Application for a non-material amendment following a grant of planning permission.
 Town and Country Planning Act 1990

Refurbishment of Larwood House to modernise the facility internally and externally, erect two storey extensions and carry out associated landscape works. Reconfiguration of the flats to provide larger, modernised living accommodation and updated communal facilities and reroofing and recladding works to upgrade the façade.

20/01667/FUL

Title  
**Proposed Ground Floor Plan**

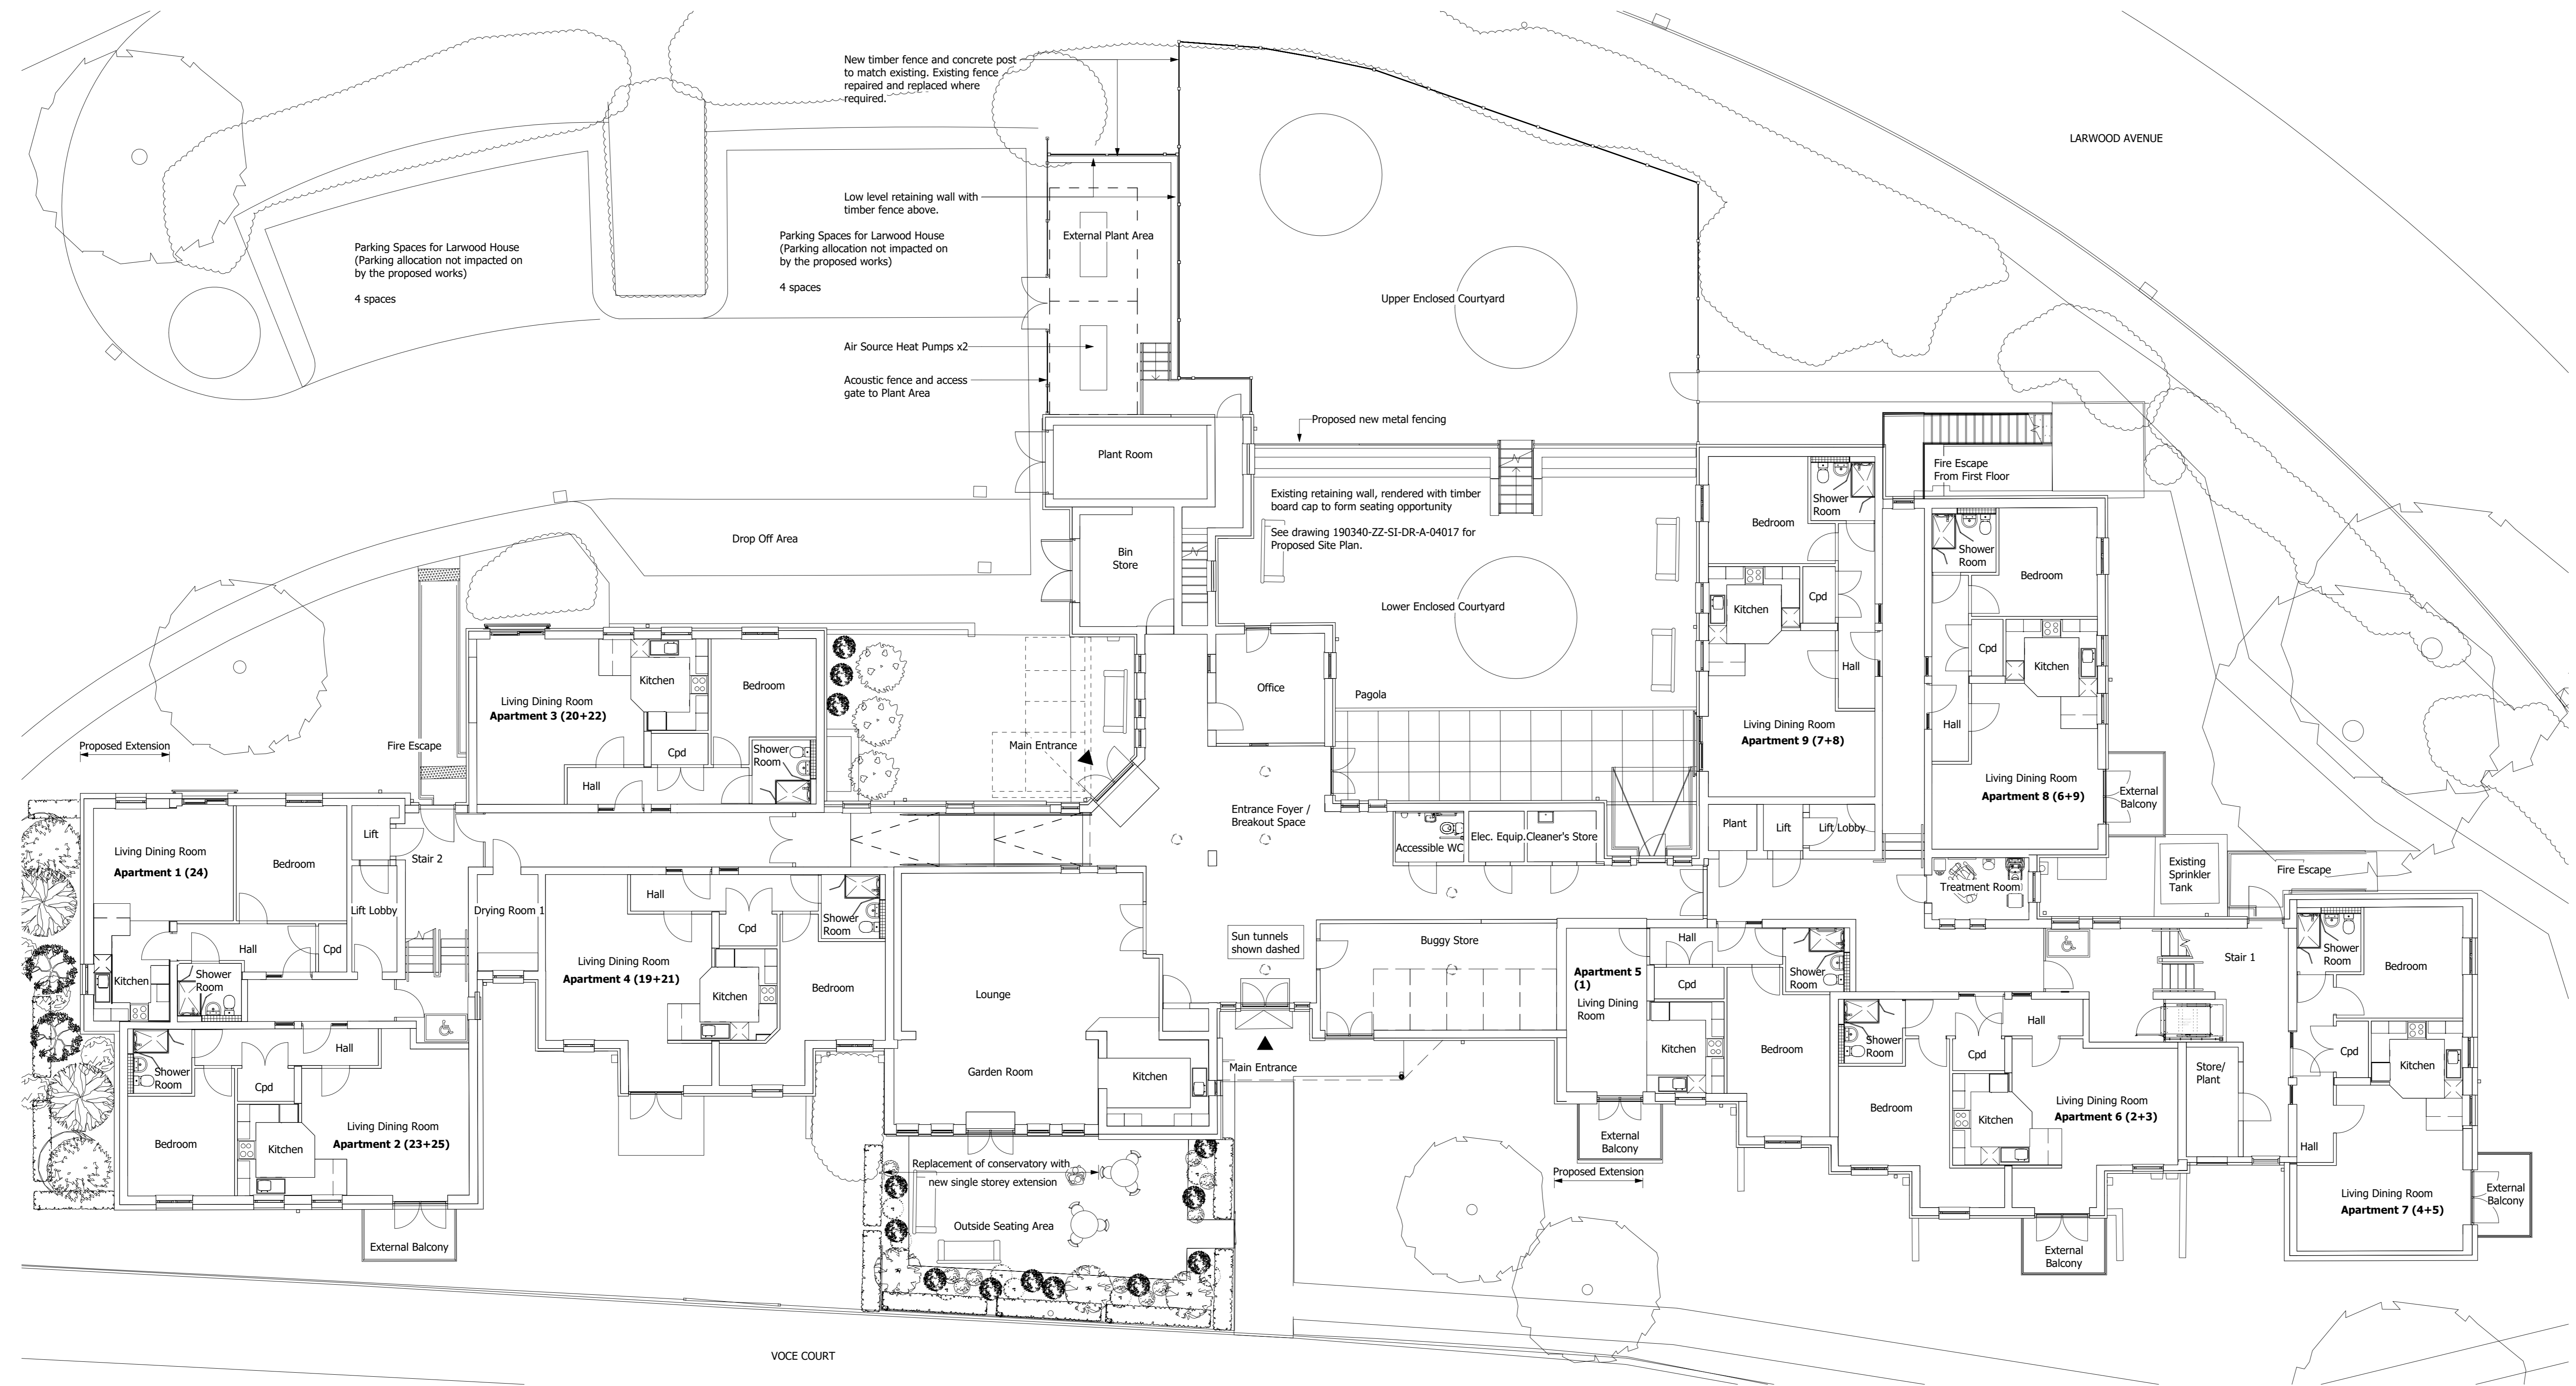
The Former Warden's House and associated garden were highlighted on the original drawings as extent of works to be confirmed. The attached drawings show that the confirmed proposal now is for the Former Warden's House to be demolished and the garage to be used to house the internal plant equipment for Larwood House. The garden area will be altered and become an extension of the enclosed courtyard. The area of landscaping to the front of the Former Warden's House will be regraded to accommodate the external plant equipment that will be enclosed by an acoustic fence. Please see attached letter for further information.

Title
Proposed Site Plan

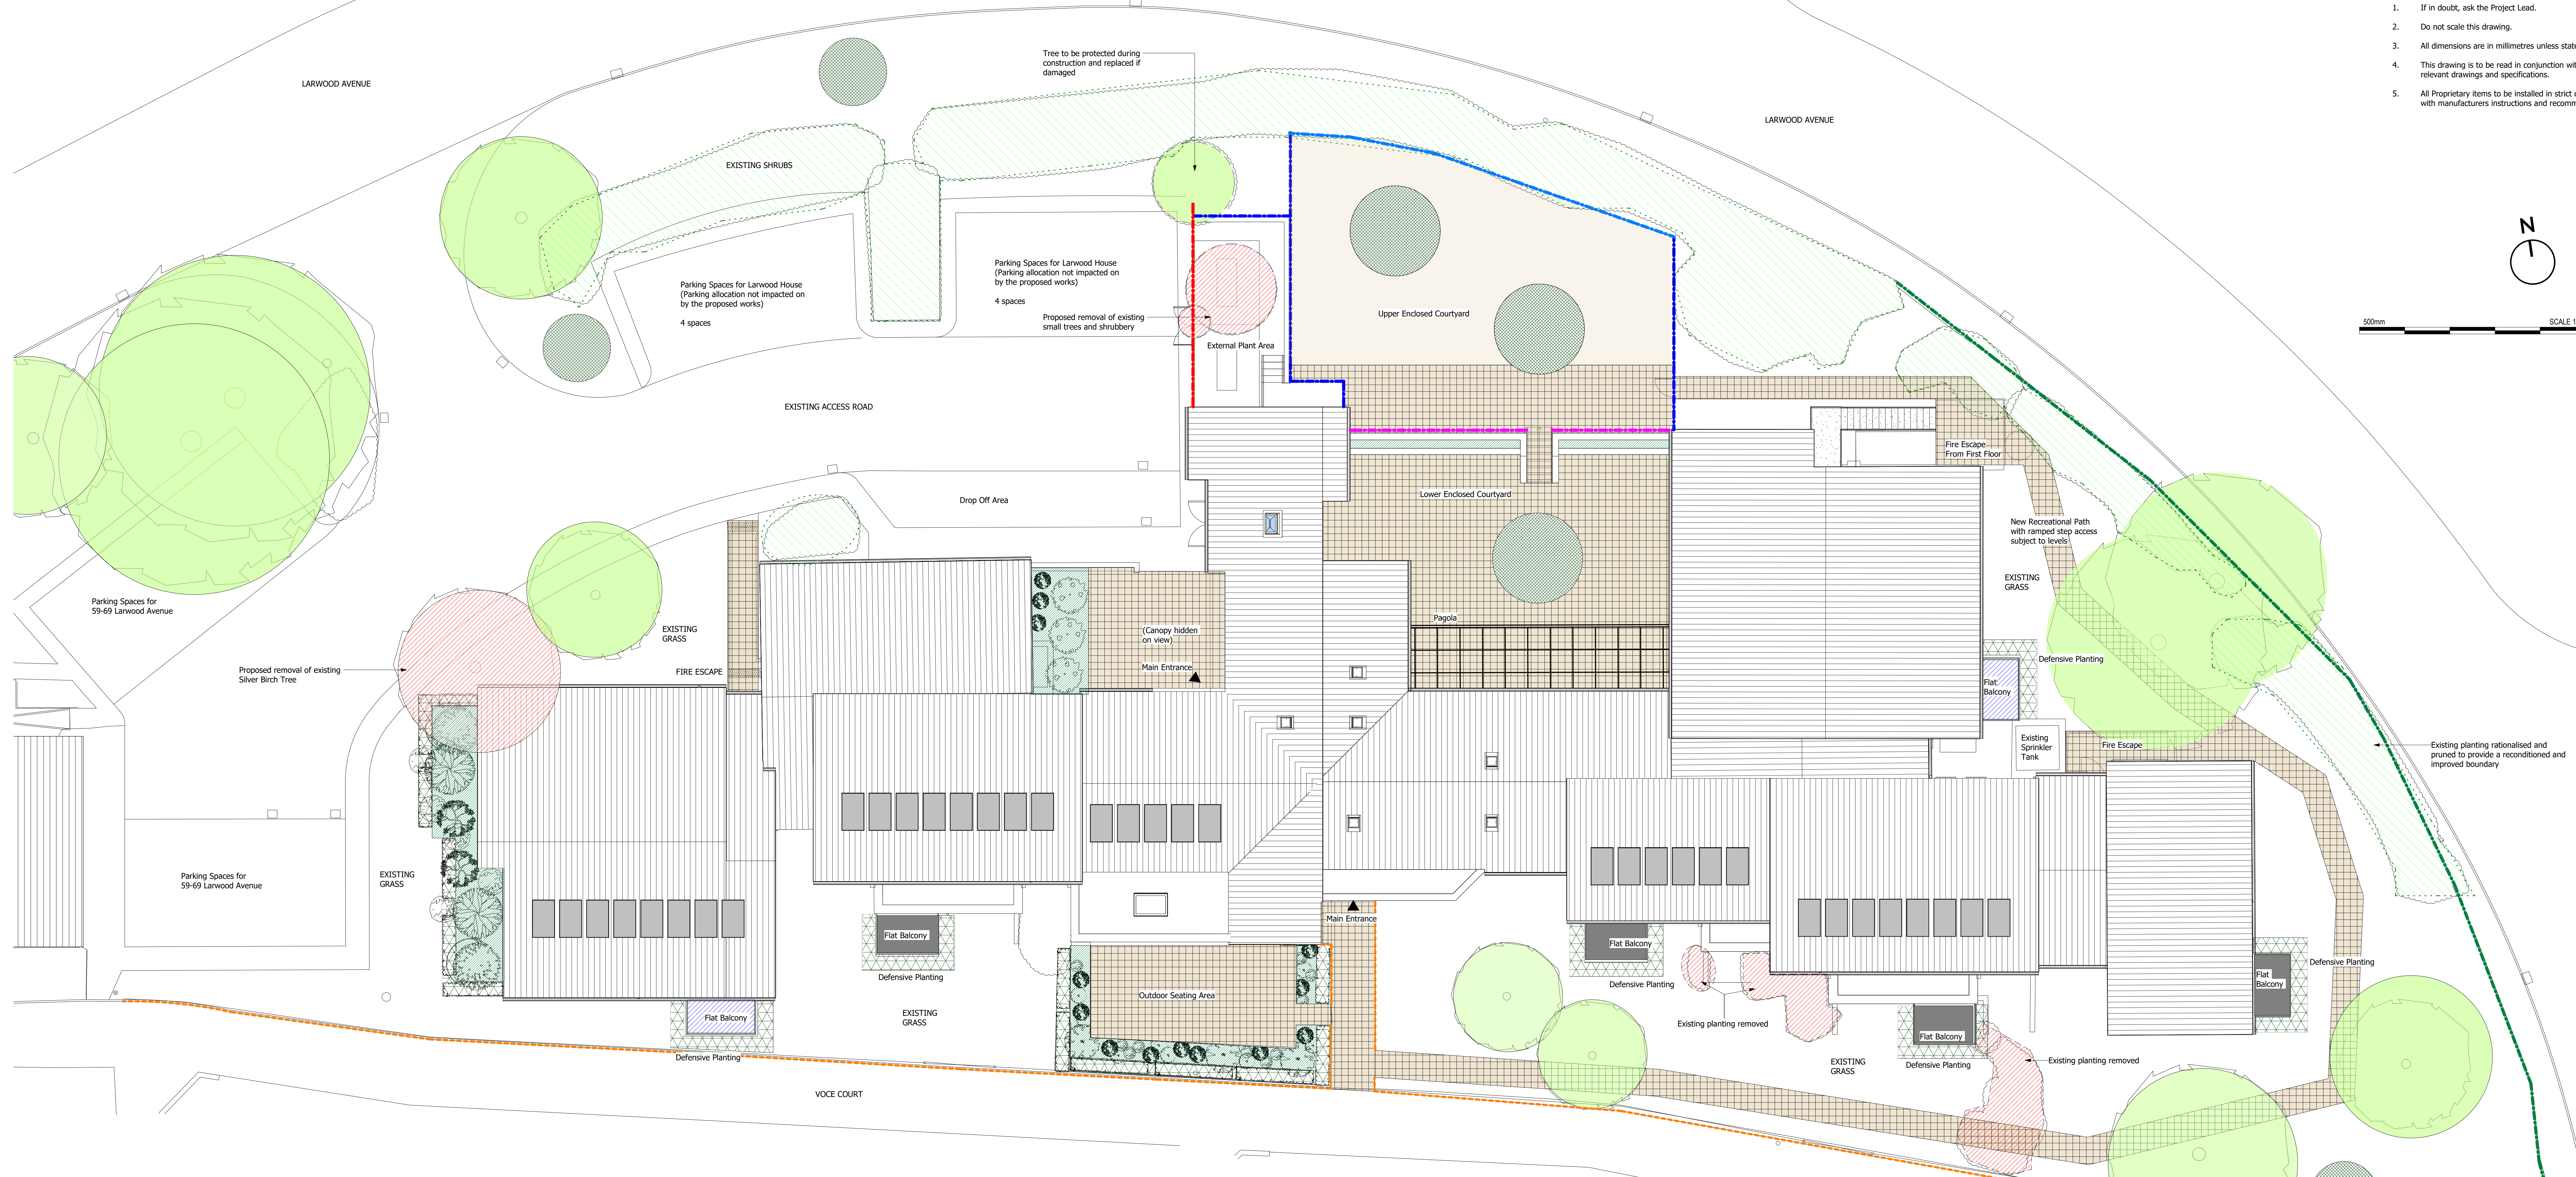
Several proposals were tabled on how to integrate the house into the wider scheme, these included retaining as a separate house and converting it to flats. However, it was felt that in part but not limited to the existing external levels and ability to connect it back to Larwood House reduced its viability. Changes in the plant equipment requirement meant that an external area was required to house these within relative proximity to the internal plant room. Through the demolition of the house and hard landscaping the plant area is a formed.
